David Wilkinson

Helios EN010140

Reg 20050592

01/06/2025

Environmental Statement Figure 11.4: Noise Contour Map Daytime

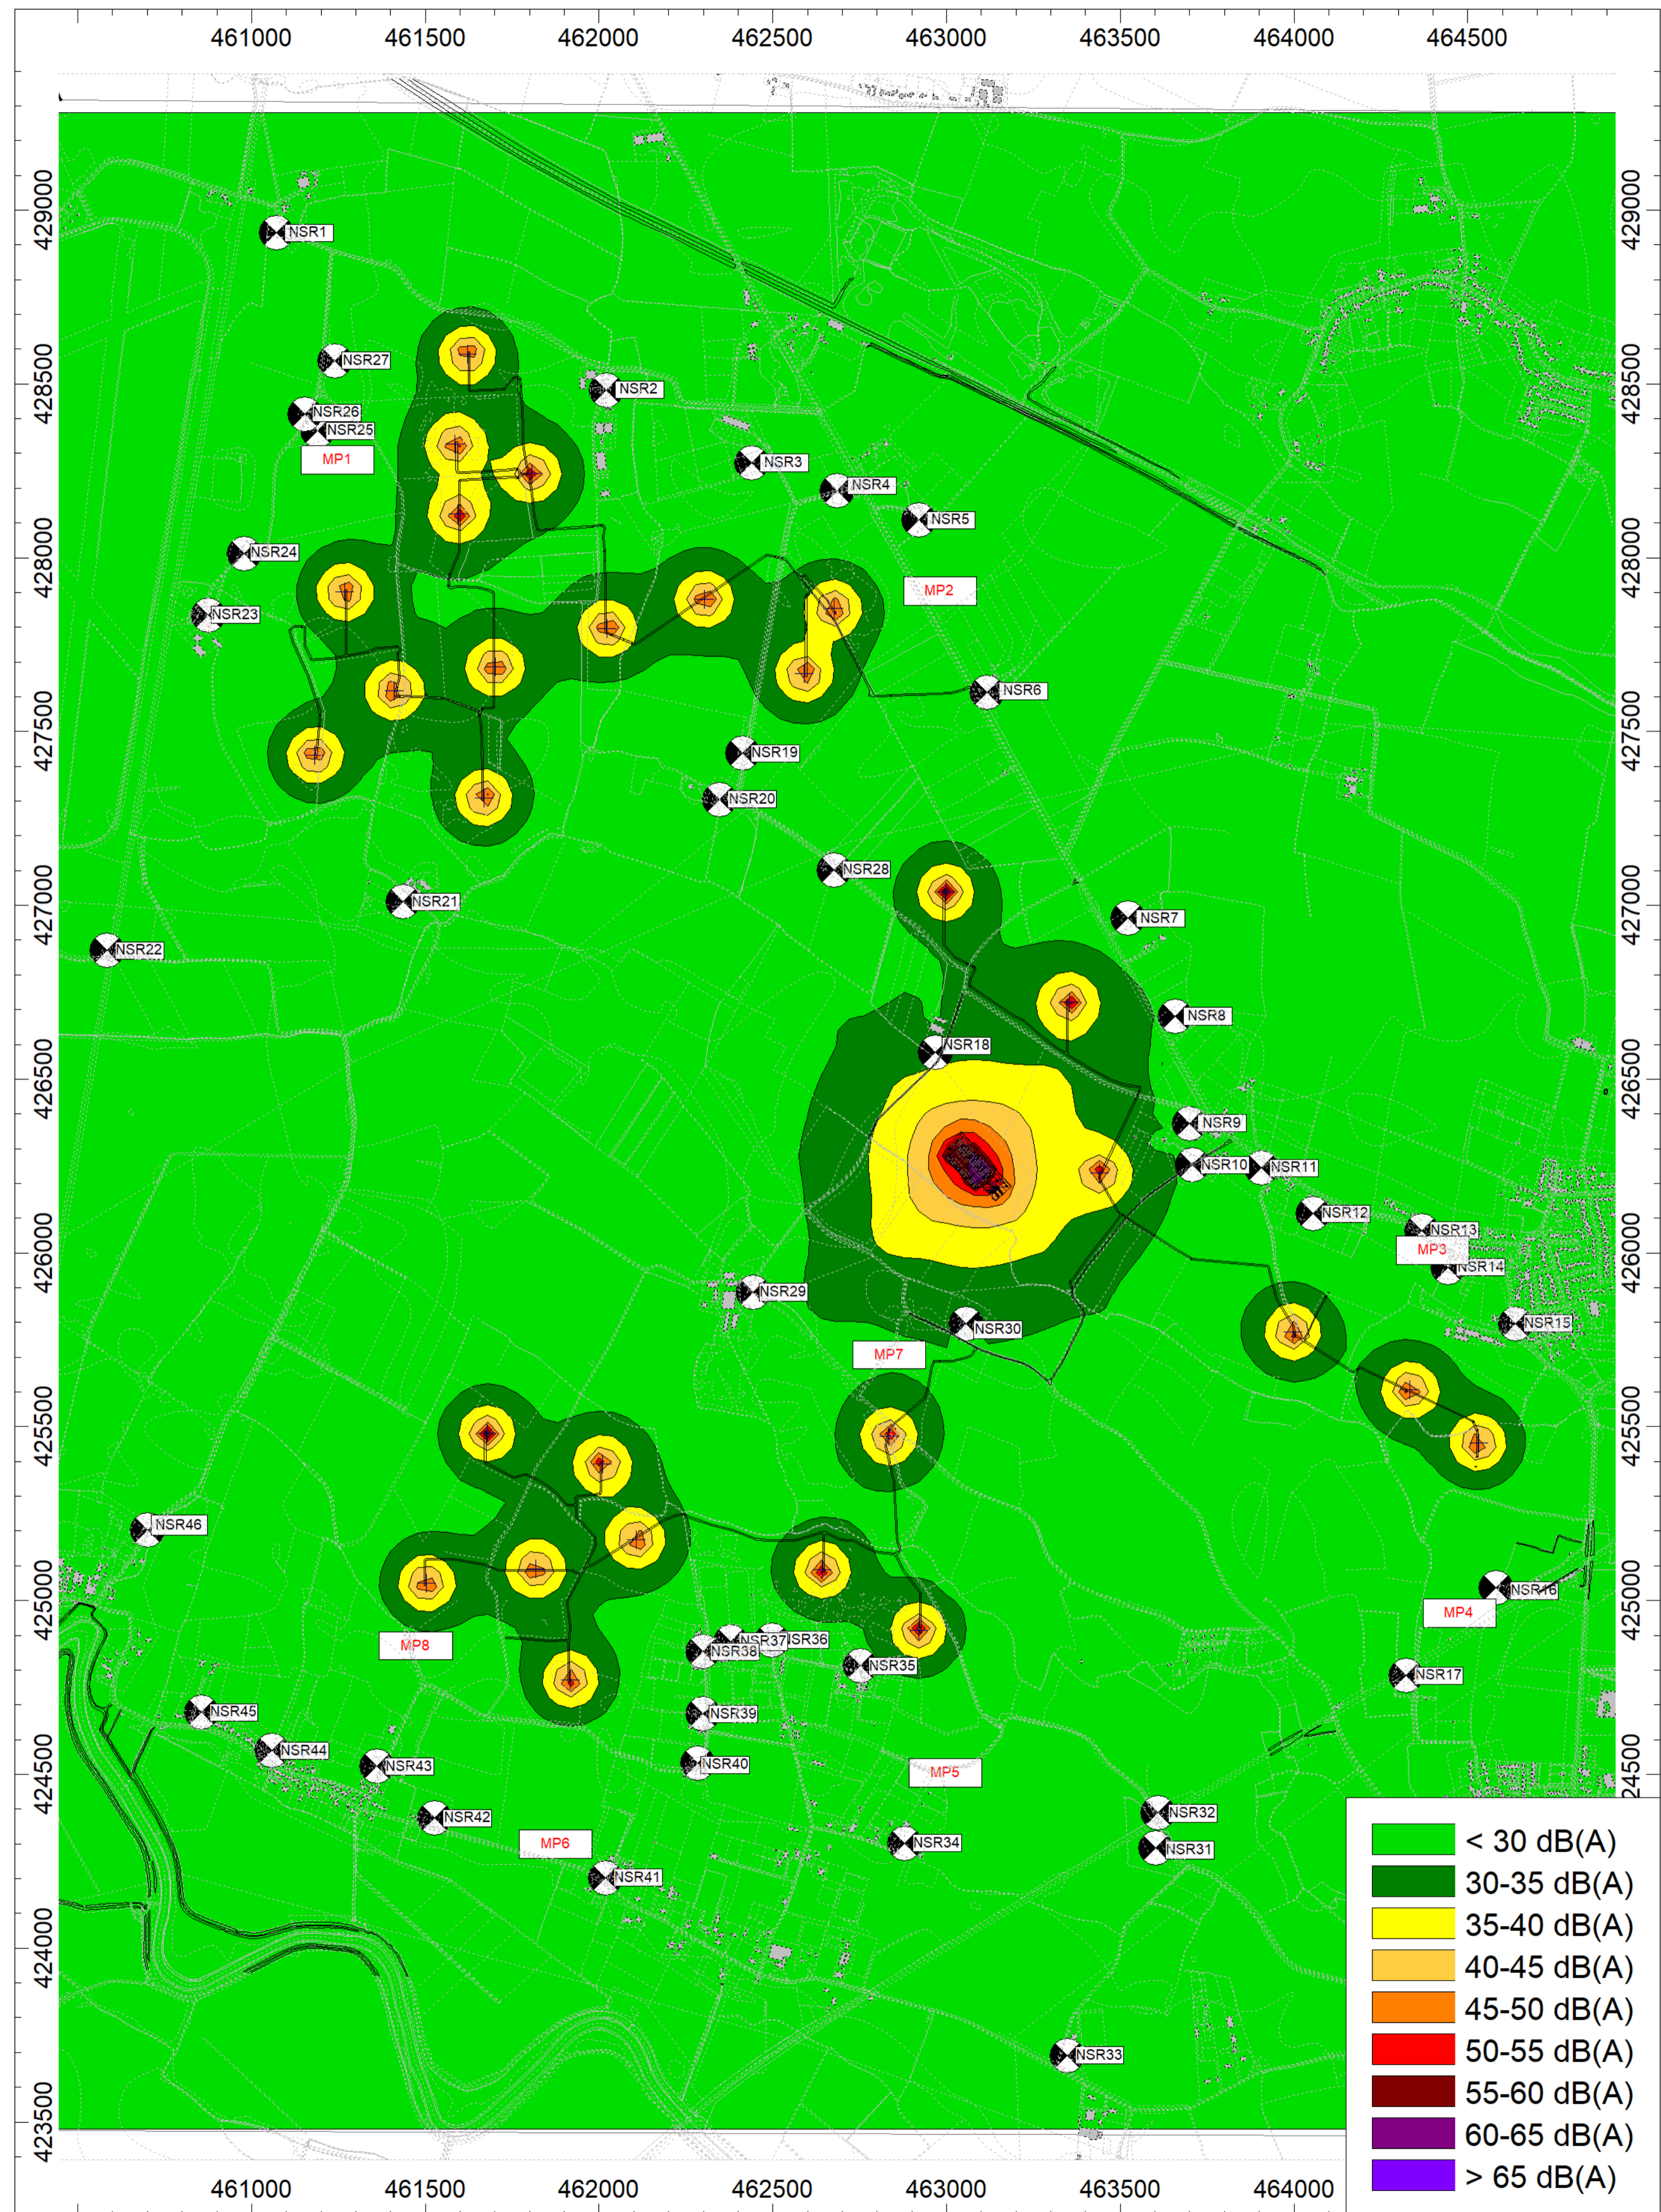
With regard to my last Deadline 9 Publication, reference to Environmental statement Figure 11.4 (The map I have supplied numbered 7 on my original publication dated 24 March 2025), has a symbol Z? which I have added, requiring some explanation please. Whatever it/they are, I have counted 28 in total. They have the capability of emitting 45-50 dB of noise. The Z? in question is ALMOST AT THE BOTTOM OF MY GARDEN. Due to the poorly detailed map, I could not get a fixed position to measure approx., how close it would be to my property. Please attach this map to my Deadline 9 publication as it is better quality which was sent by registered mail.
